CITY OF ALBUQUERQUE

**RE: Coors Pavilion Subdivision
9154 Coors Blvd
Grading Plan
Engineer's Stamp Date 01-04-2017 (File: G11D069)**

Based upon the information provided in your submittal received 01/13/2017, the Grading Plan is not approved for Grading Permit. The following comments need to be addressed for approval of the above referenced project:

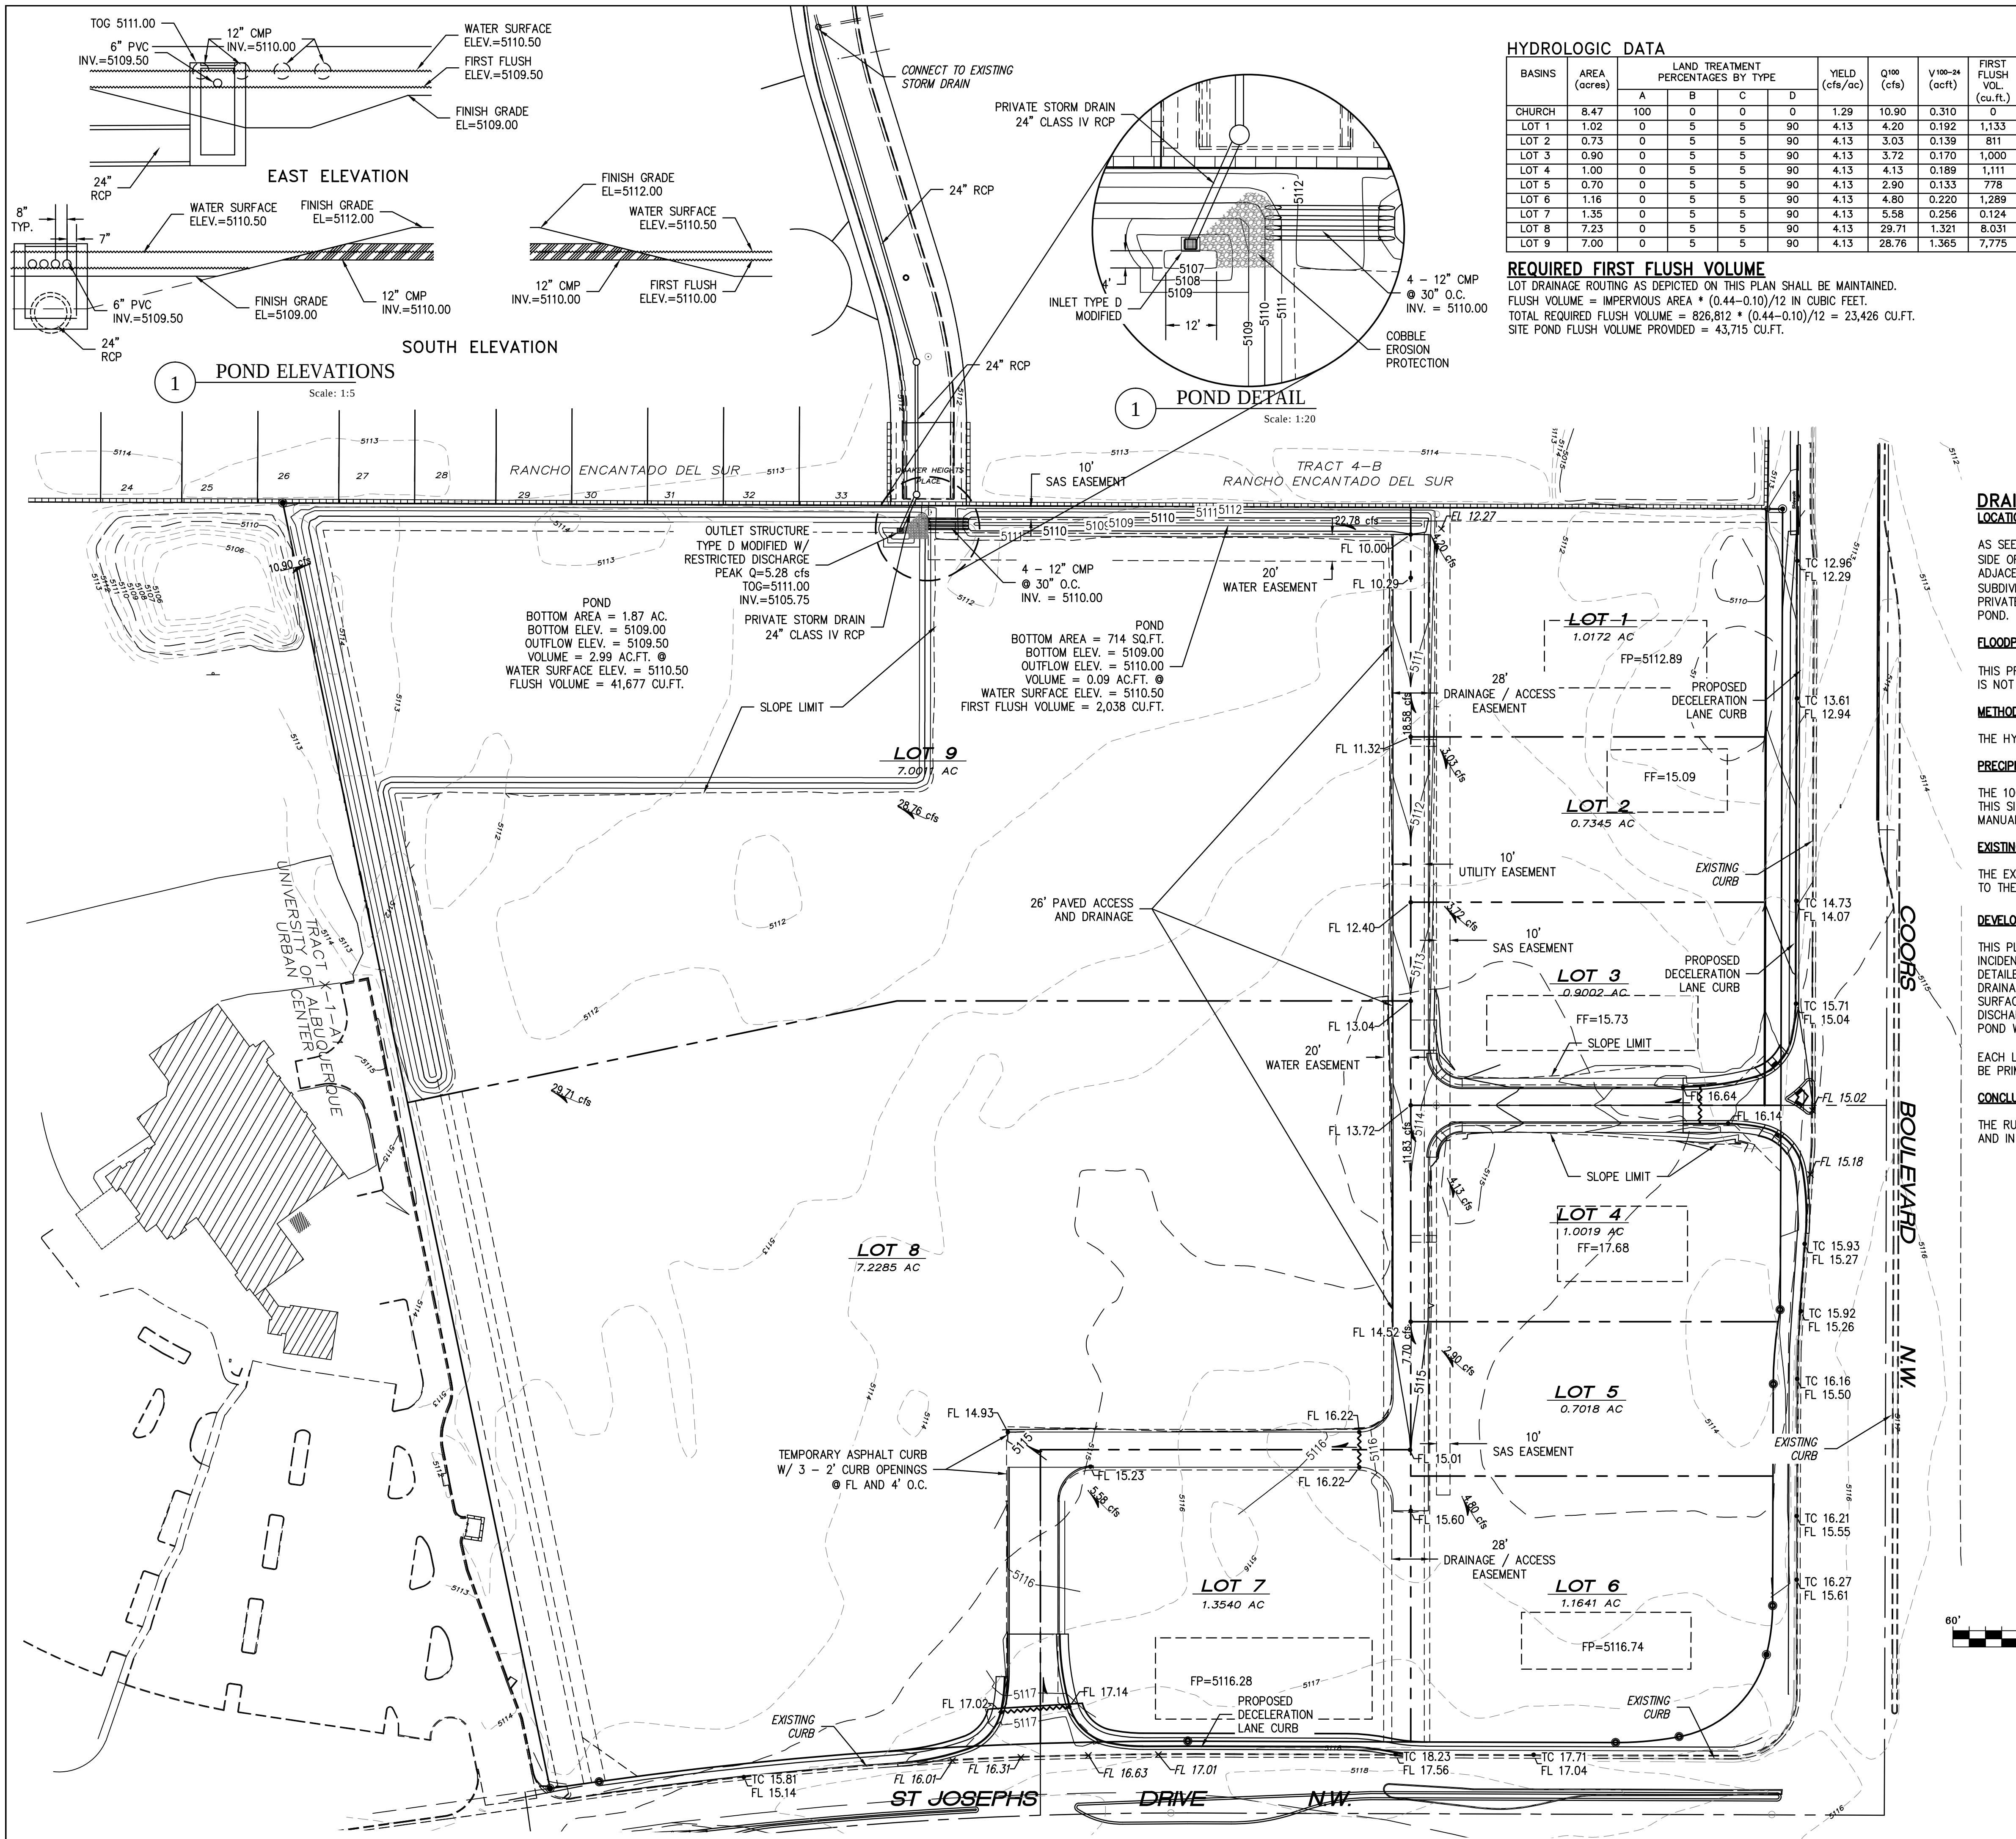
1. The AHYMO model routes discharge from Lot 7 into Lot 6, and along the alley to the north, then into the pond. However the drainage narrative and the drawing show Lot 7 as draining into Lot 8, then to the pond. The AHYMO model needs to reflect the drawing and narrative or visa-versa.

2. If discharge from Lot 7 is to be drained into Lot 8, a curb cut and dip section will need to be provided to take water out of the alley and into Lot 8.

3. Waterblocks will be required where the alley joins Coors and St. Josephs to prevent excess flows from entering and contributing to the drainage area. These may be present already but are difficult to see; provide spot elevations and callouts to clarify.

4. Clarify contributions from adjoining lot X-1-A1. The AHYMO model appears to refer to this as "Church" with a contribution of 10.68 cfs and 0% impervious area. The drawing shows a contribution of 29.26 cfs. Is the existing pond being merged with the new one?

5. Proposed contours need to be added to the legend and to the lots. On this sheet no regrading appears to be taking place across the new lots.
6. The proposed water surface elevation of 5011.50 will back up into the alley and across a large portion of Lot 1. Is this desired?

7. First flush volume needs to be calculated and shown on this sheet, as well as how it will be retained in the pond beneath the invert of the outlet structure.
8. Additional detail is required on the outlet structure and its downstream effects. This includes inverts, velocities, grades, and HGL's.
9. Provide the input and output files for the AHYMO model.
